8 February 2022

**Advice on Response to Submissions  
Sydney Football Stadium - New Precinct Village and Carpark  
Stage 1 - SSD-9429 - Modification 6; and  
Stage 2 - SSD 9835 - Modification 7**

2 SSDA ROOF LEVEL WEST
SCALE 1 : 250

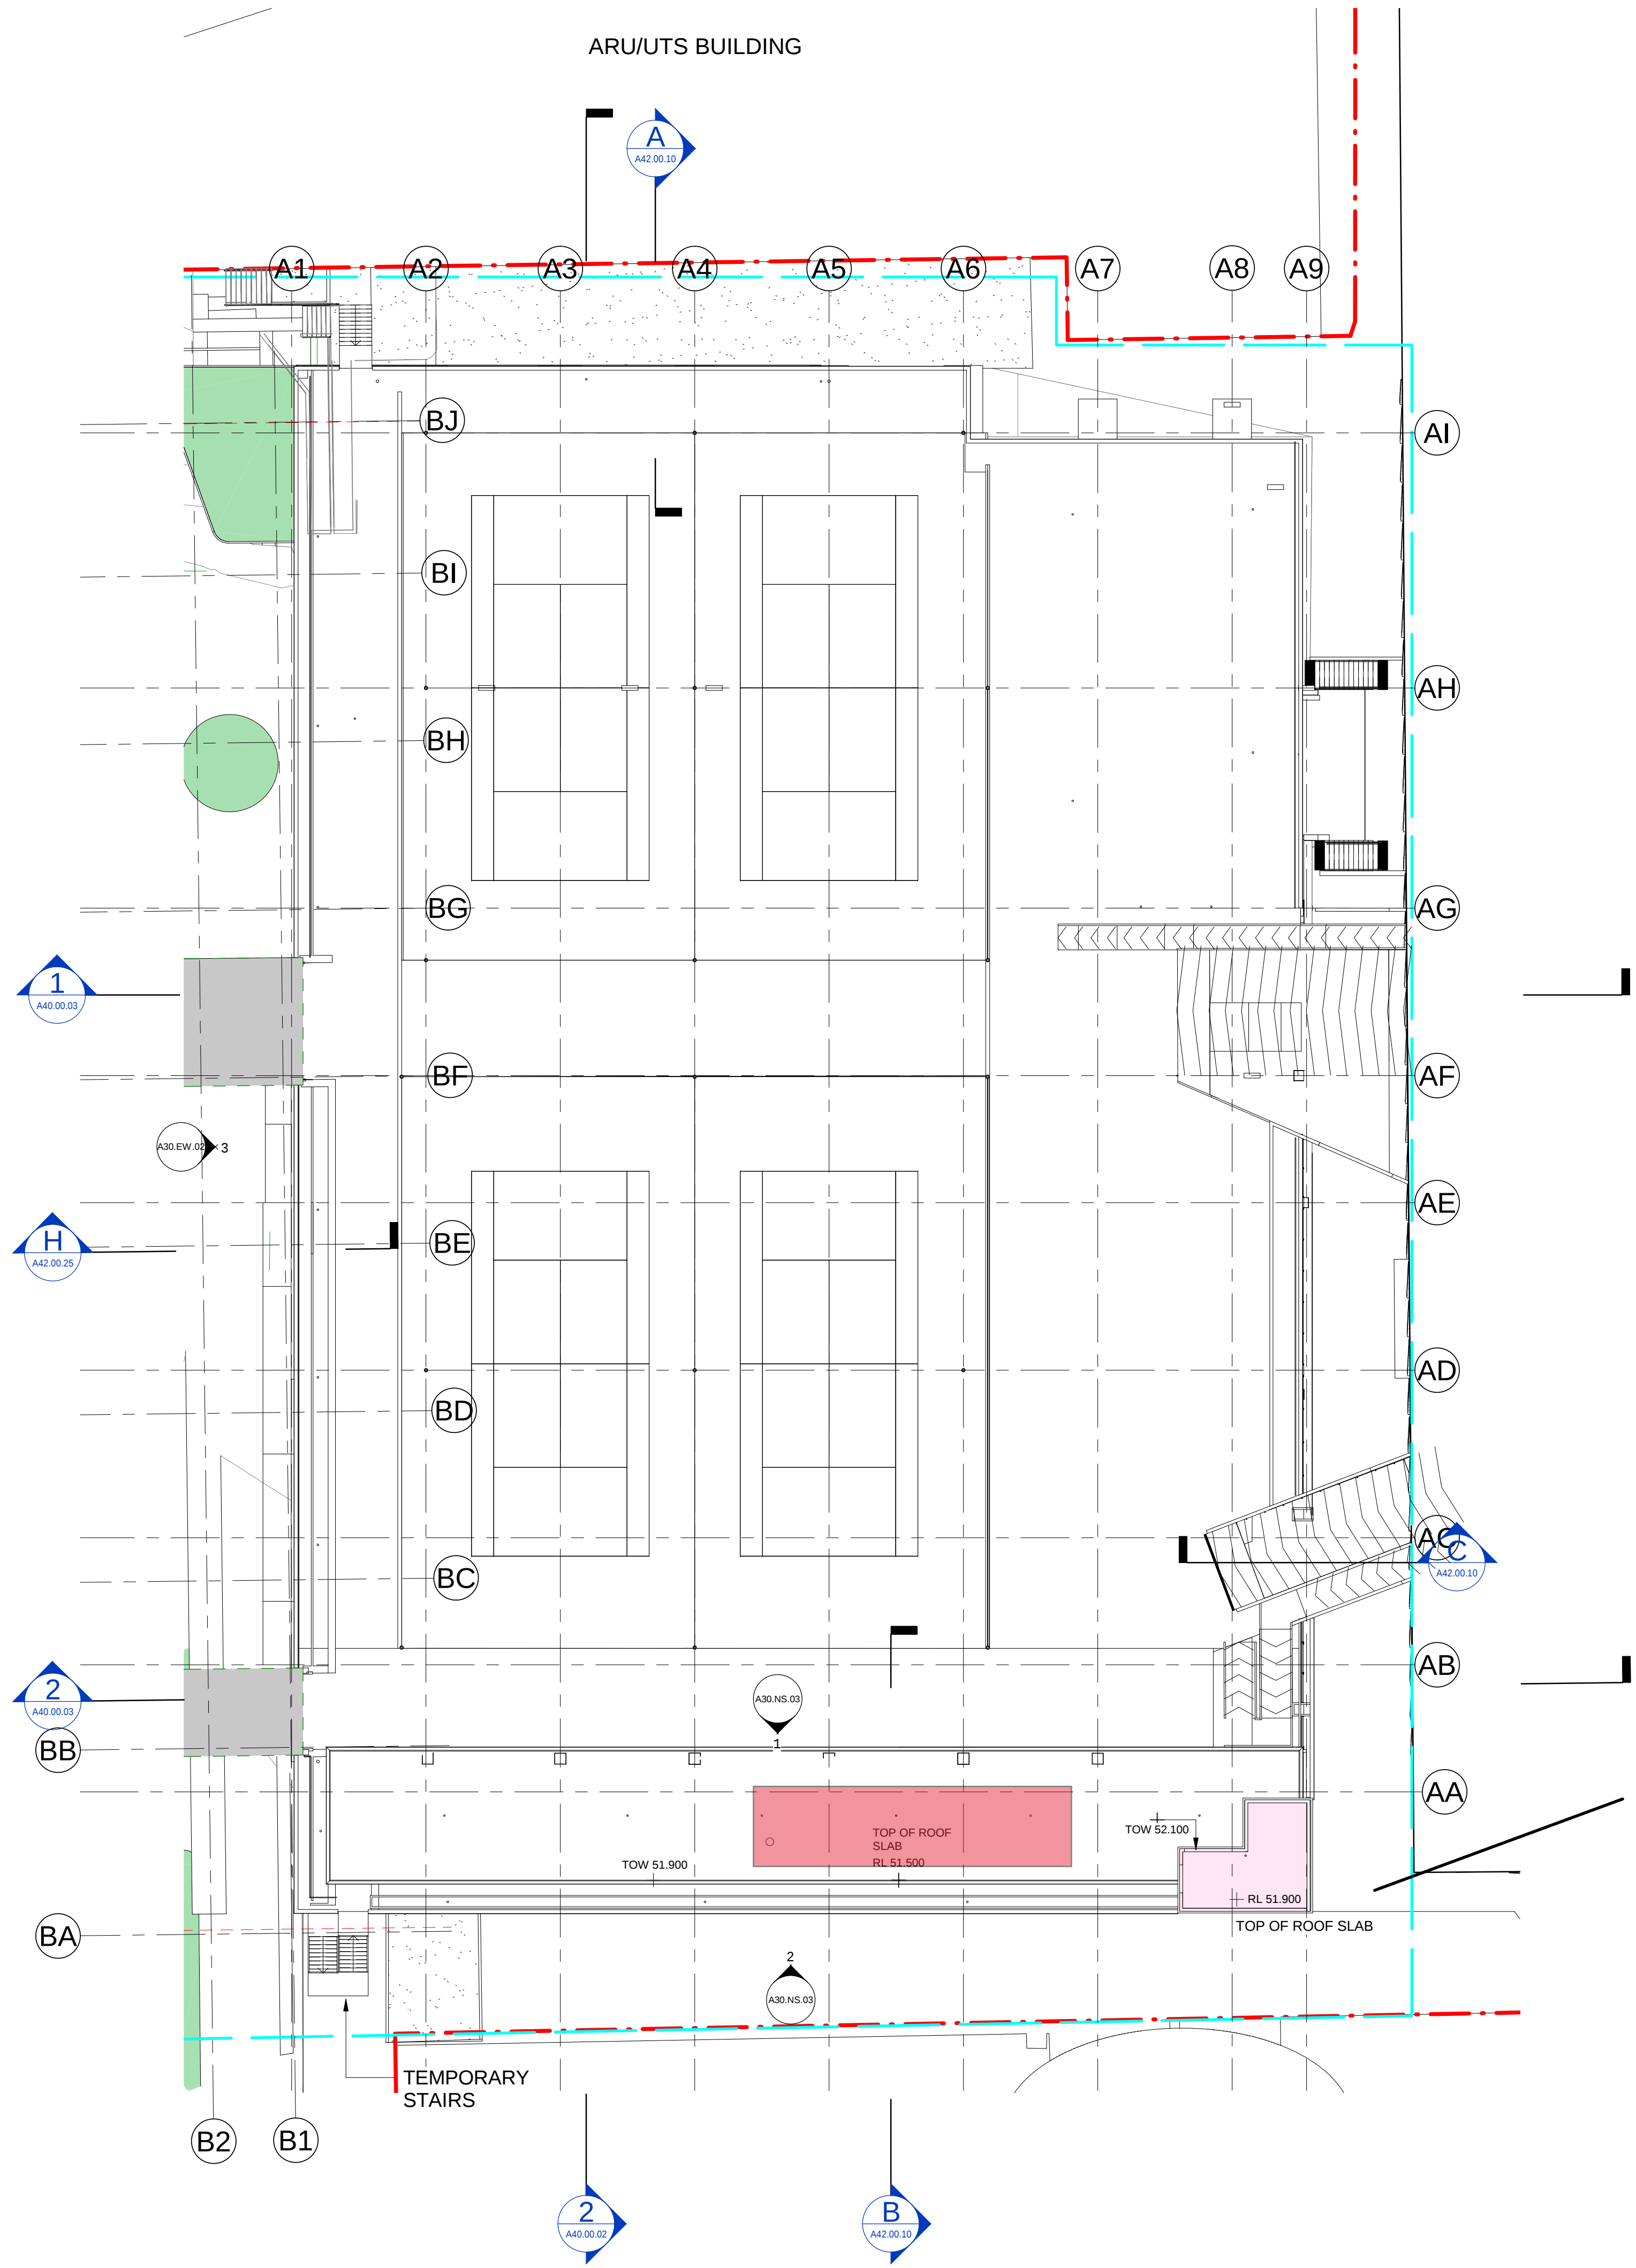
- The plans show that the green roof above the Tennis Club has been removed and replaced with pebbles. This reduces the overall greening of the site, local biodiversity, cooling, thermal efficiency, water polishing and stormwater runoff benefits that result from a green roof. The replacement with pebbles is a poor outcome and is not supported by the City.
- In addition to providing a green roof, this is also a prime opportunity to provide PV panels. [Research led by UTS](#) has found that combining solar panel installations with green roofs can result in benefits to energy production, stormwater filtration and animal biodiversity.

The Design Integrity Panel (in minutes dated 6 December 2021) queried whether PV array will be provided on top of the tennis club roof and the applicant advised that the roof is expected to be covered by PV panels.

The provision of PV panels has already been significantly reduced under Mod 4 of SSD-9835. Therefore, PV panels should be provided on the Tennis Club roof and details of this should be shown on the architectural plans and form part of any amended consent.

- The Tennis Club Roof should feature a green roof and PV panels.

Figure 1 Extent of updated traffic model

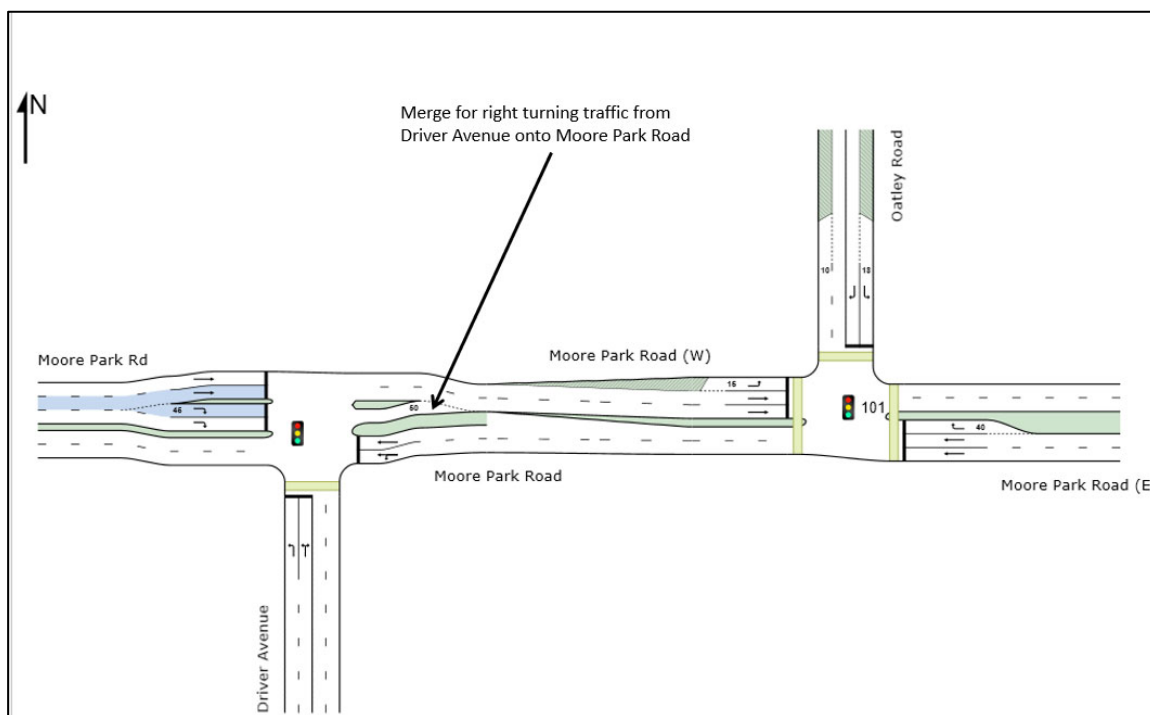
- The City requested a network model to assess the right turn from Driver Avenue and merge with the existing traffic on Moore Park Road. This has not been provided.
